Rezoning Transportation Analysis

Petition Number: 2020-125

General Location Identifier: Tax ID 05112203

Date	Description
10-26-20	First Review
11-30-20	Second Review
12-28-20	Third Review
01-26-21	Fourth Review

Rezoning Site Plan

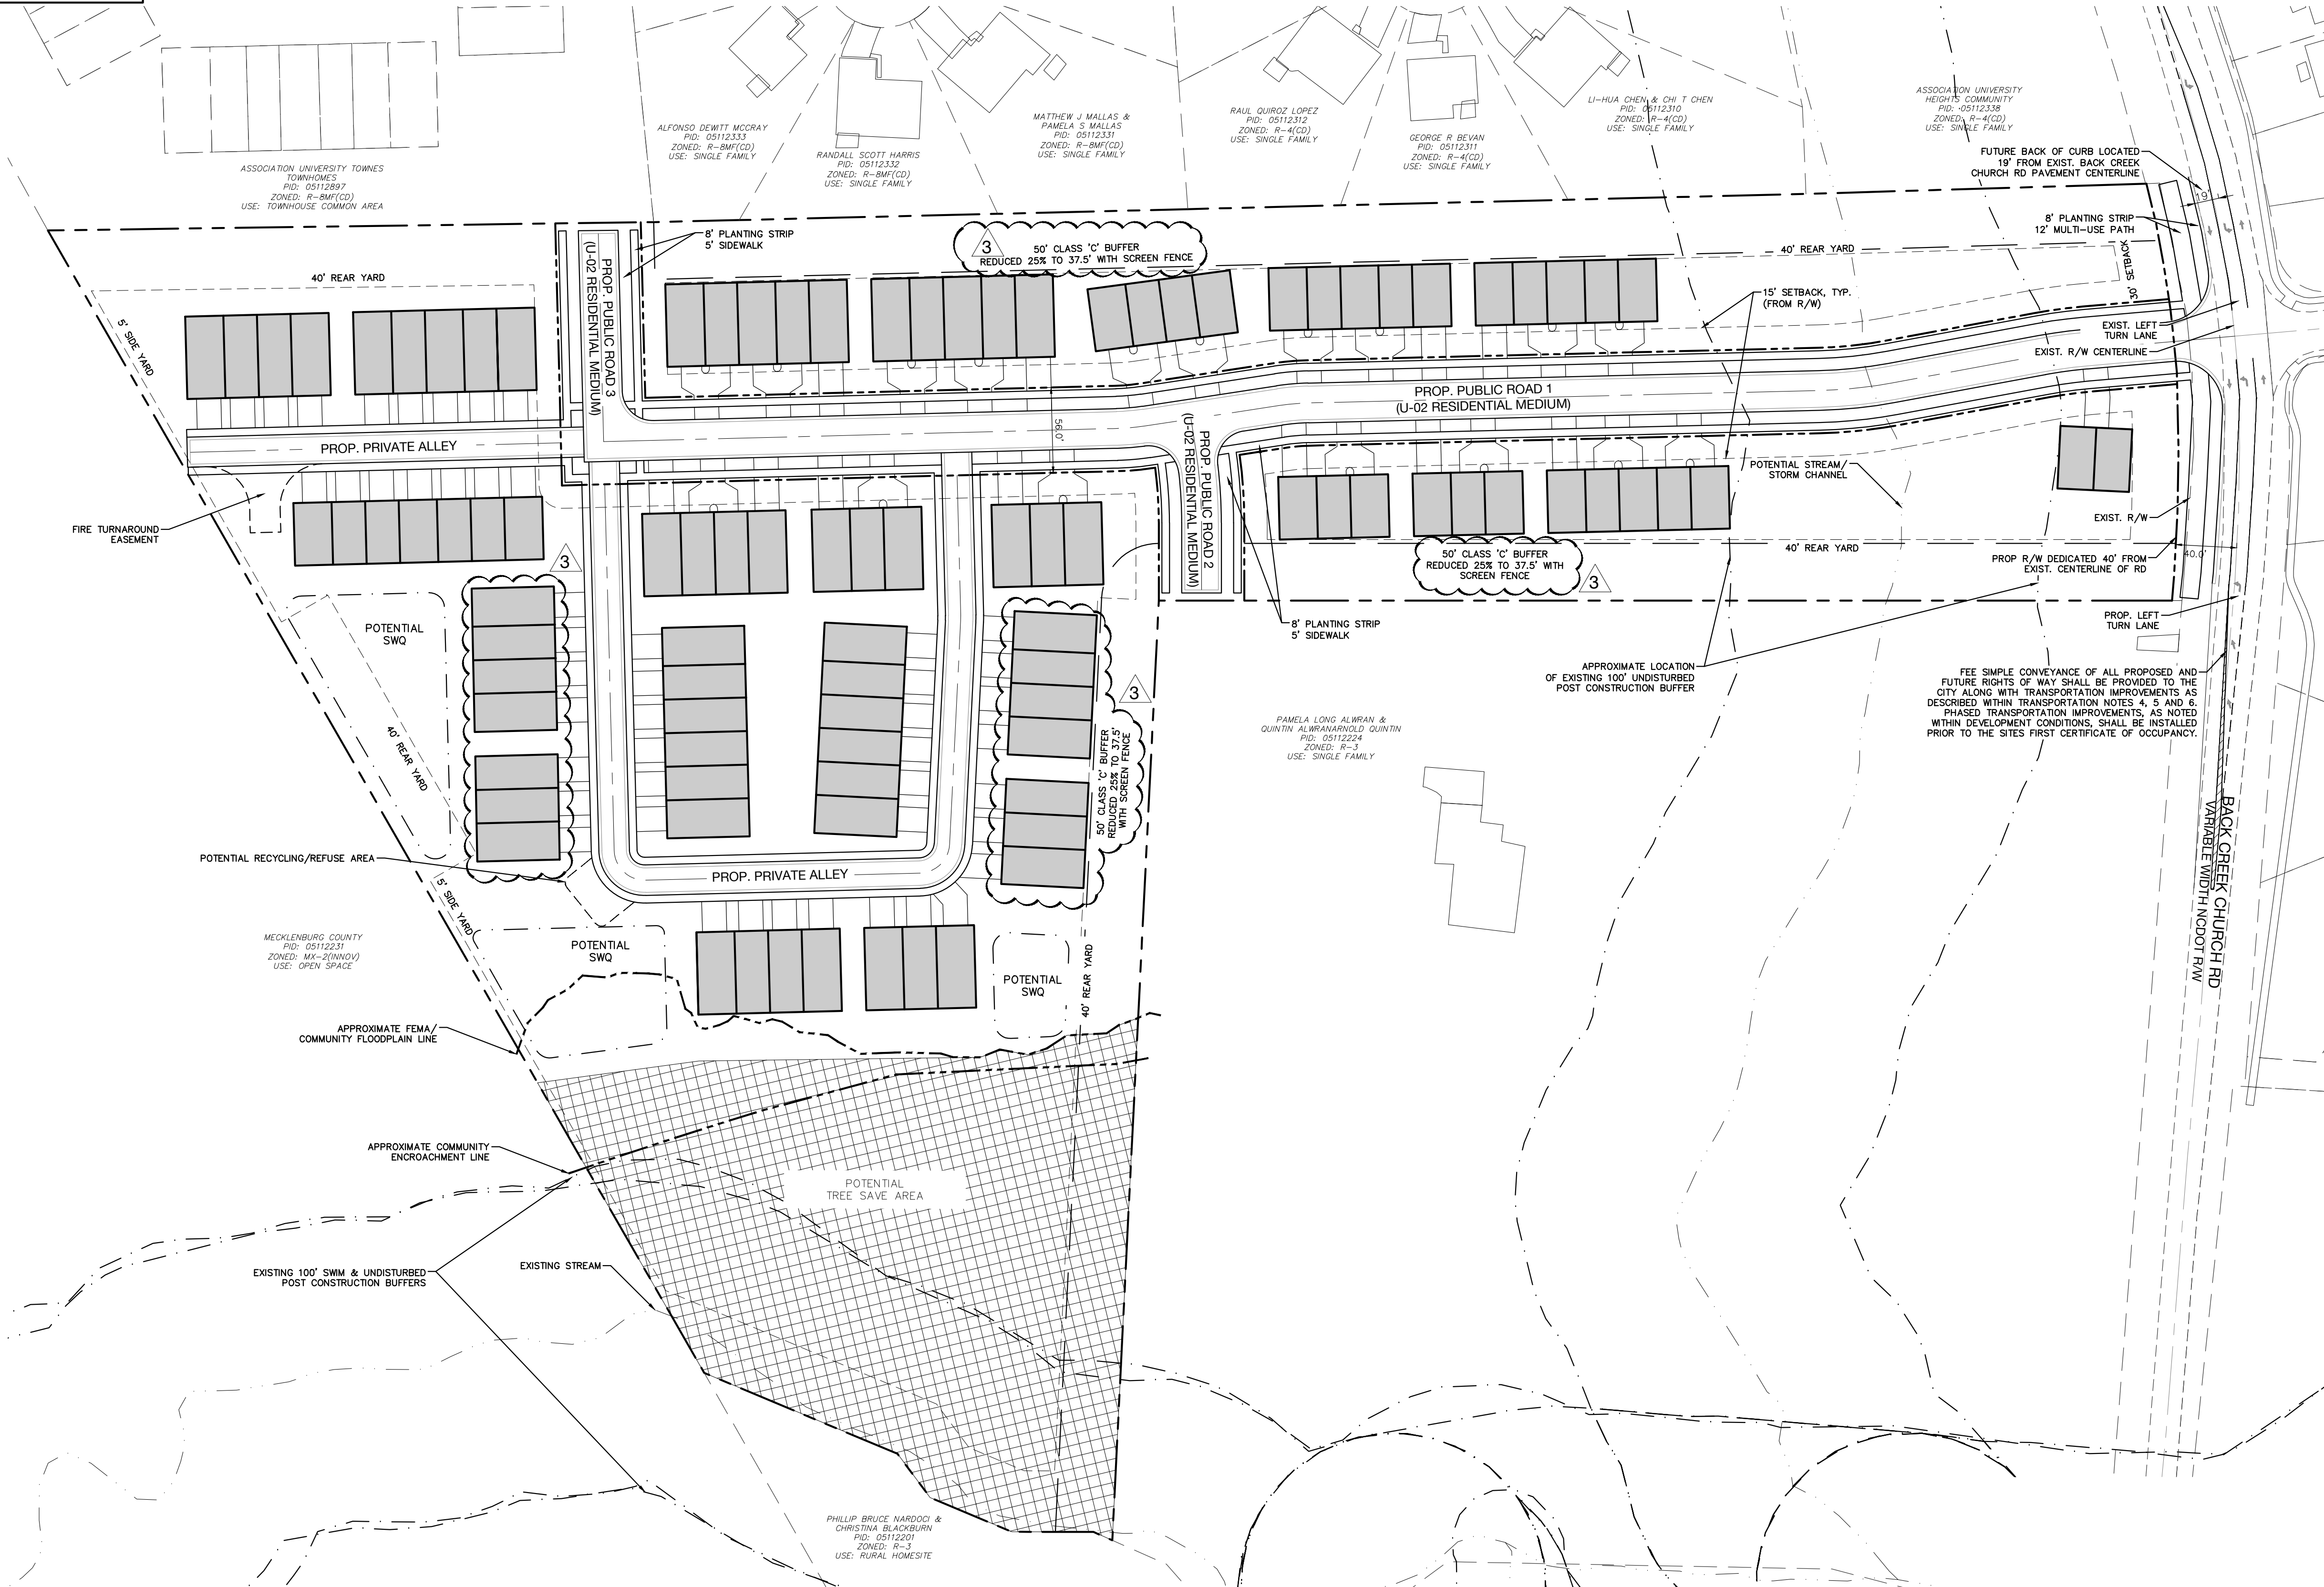
1. **Curblines:** ~~The proposed zoning district has a setback measured from back of the existing or proposed future curblines.~~
 - a. ~~**Back Creek Church Road:** The back of curb and gutter shall be located at 19' from the roadway centerline. This accounts for two 11' through lanes, 2.5' curb and gutter, and an 11' left turn lane at the site's entrance.~~

~~The site plan should show the curb and gutter labeled and dimensioned from the centerline for each road.~~
2. **Traffic Study:**

3. ~~Revise the site plan and conditional note(s) to commit to dedicating 40' minimum right of way from the Back Creek Church Road centerline. The site plan shall label and dimension the right-of-way from the road centerline.~~

4. ~~Revise the site plan and conditional note(s) to commit to constructing an 8-foot planting strip, and 6-foot sidewalk on all Local roads per Chapter 20 and CLDSM Standard U-03. While the site plan shows both, they need to be labeled and dimensioned accurately from the back of curb and gutter.~~

5. ~~The site plan and conditional note(s) revisions are needed to commit to installing a 12' multi-use path along Back Creek Church Road to meet the City Charlotte BIKE Policy.~~

6. ~~Revise the site plan and conditional note(s) to commit to providing a left turn lane into the development as required for developments that generate over 500 trips per day, as per NCDOT's policy on street and driveway access.~~

7. ~~The proposed driveways do not meet the minimum spacing requirement of 20' per the City of Charlotte Driveway regulation. Revise site plan and conditional note(s) to commit to constructing alley loaded~~

~~homes along public roads **OR** provide shared access driveways to help produce a more organized and pedestrian-oriented form of access management per the City of Charlotte Driveway Regulation.~~
